Subject: 56, High Street, Bognor Regis - former Store Twenty One. Structural feasibility study.

Dear Will

proposed
street elevation (56 high street)
scale approx 1:200

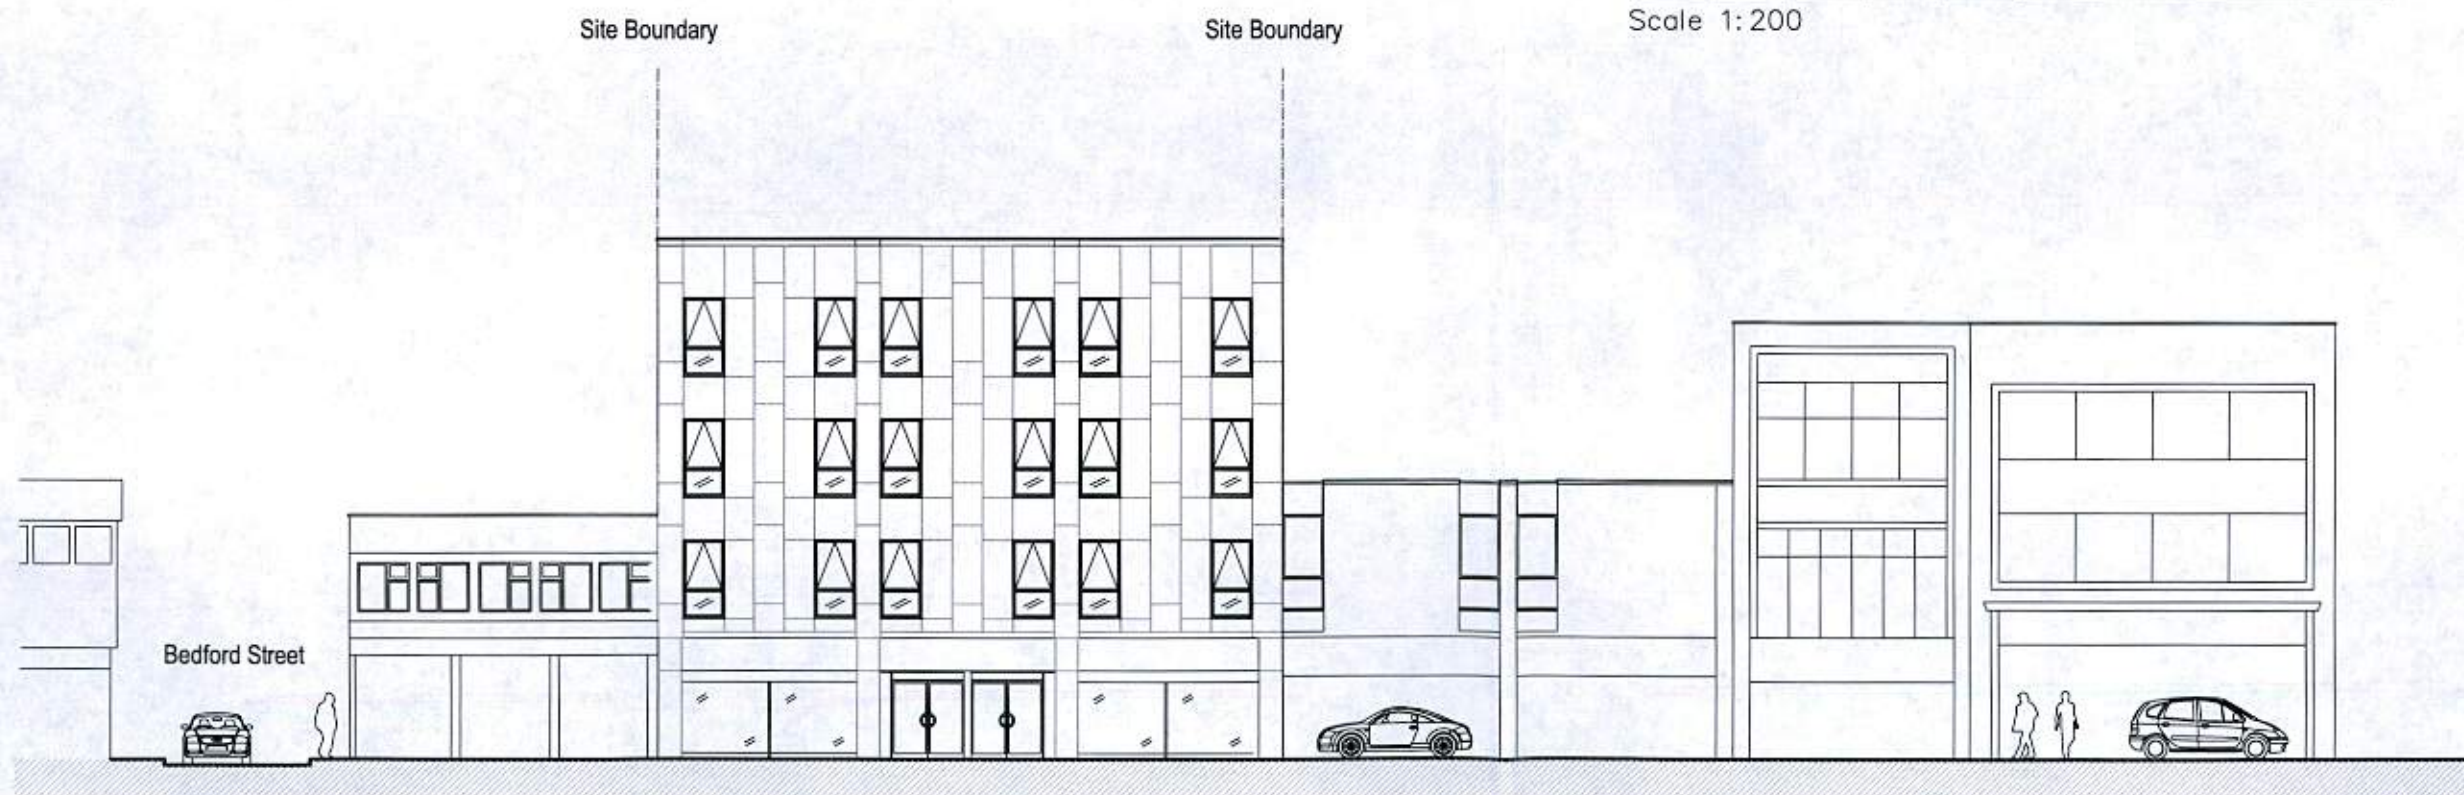
I conclude that insofar as the existing frame and foundation components are concerned there is sufficient capacity to permit the addition of two storeys specifically for domestic accommodation. There are further considerations and design provisos as follows –:

Building stiffness - there will be an increase of horizontal wind loads to the existing frameworks which we will need to consider. The retention of masonry wall components at ground floor may be necessary for the desired building rigidity but subject of further analysis.

Drawing  
**Proposed Cross Section**

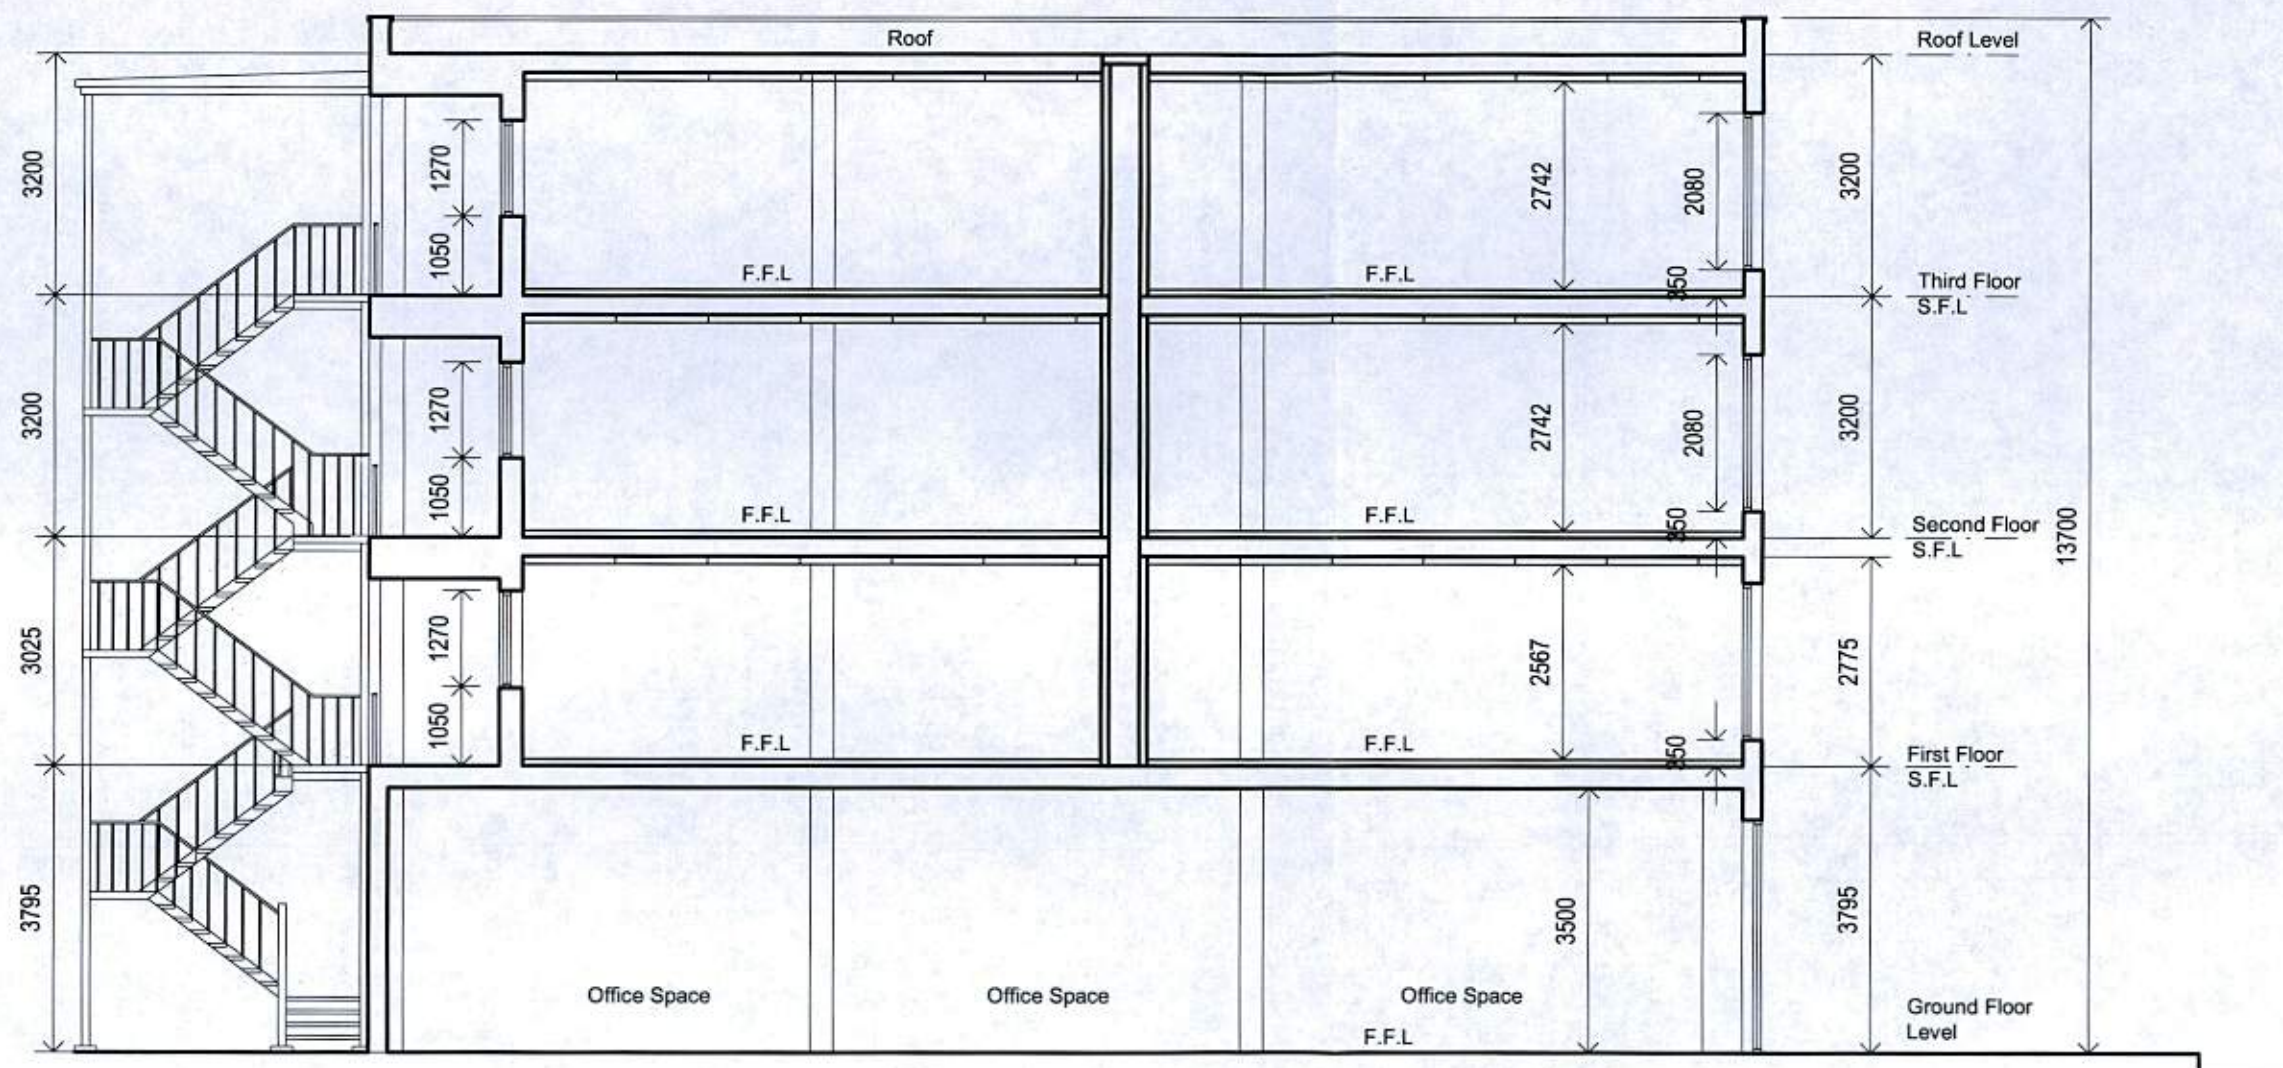
Existing 1st floor adequate by inspection since new loads will be less than existing. You will need to develop the specification for this being a party floor and this may involve some further assessment. The existing stairwell needs infilling.

Existing roof structure – there is a small increase of load to this structure estimated currently at 0.05Kn/Sq Metre but only on the basis that we can remove existing roof coverings and replace with lightweight floor surfacing. Given this then in my opinion the roof structure can be retained for use as the second floor. The specification will need to provide for this to be a Party Floor.

New 3rd floor and roof – we need the new floor and roof to be lightweight. The floor could be timber joisted to Party Floor standard and roof preferably metal deck or similar. The whole could potentially be an offsite package in timber or metal frame. All loads must be directed back to the current column positions and this will demand a column and beam frame designed for lateral wind loads.

Rear wall 1st to 2nd – this will be lightweight but will set up a line load on the existing first floor. This is something we will address as the design is developed but may demand some local enhancement. New upper floor walls will be supported on frameworks but must be lightweight.
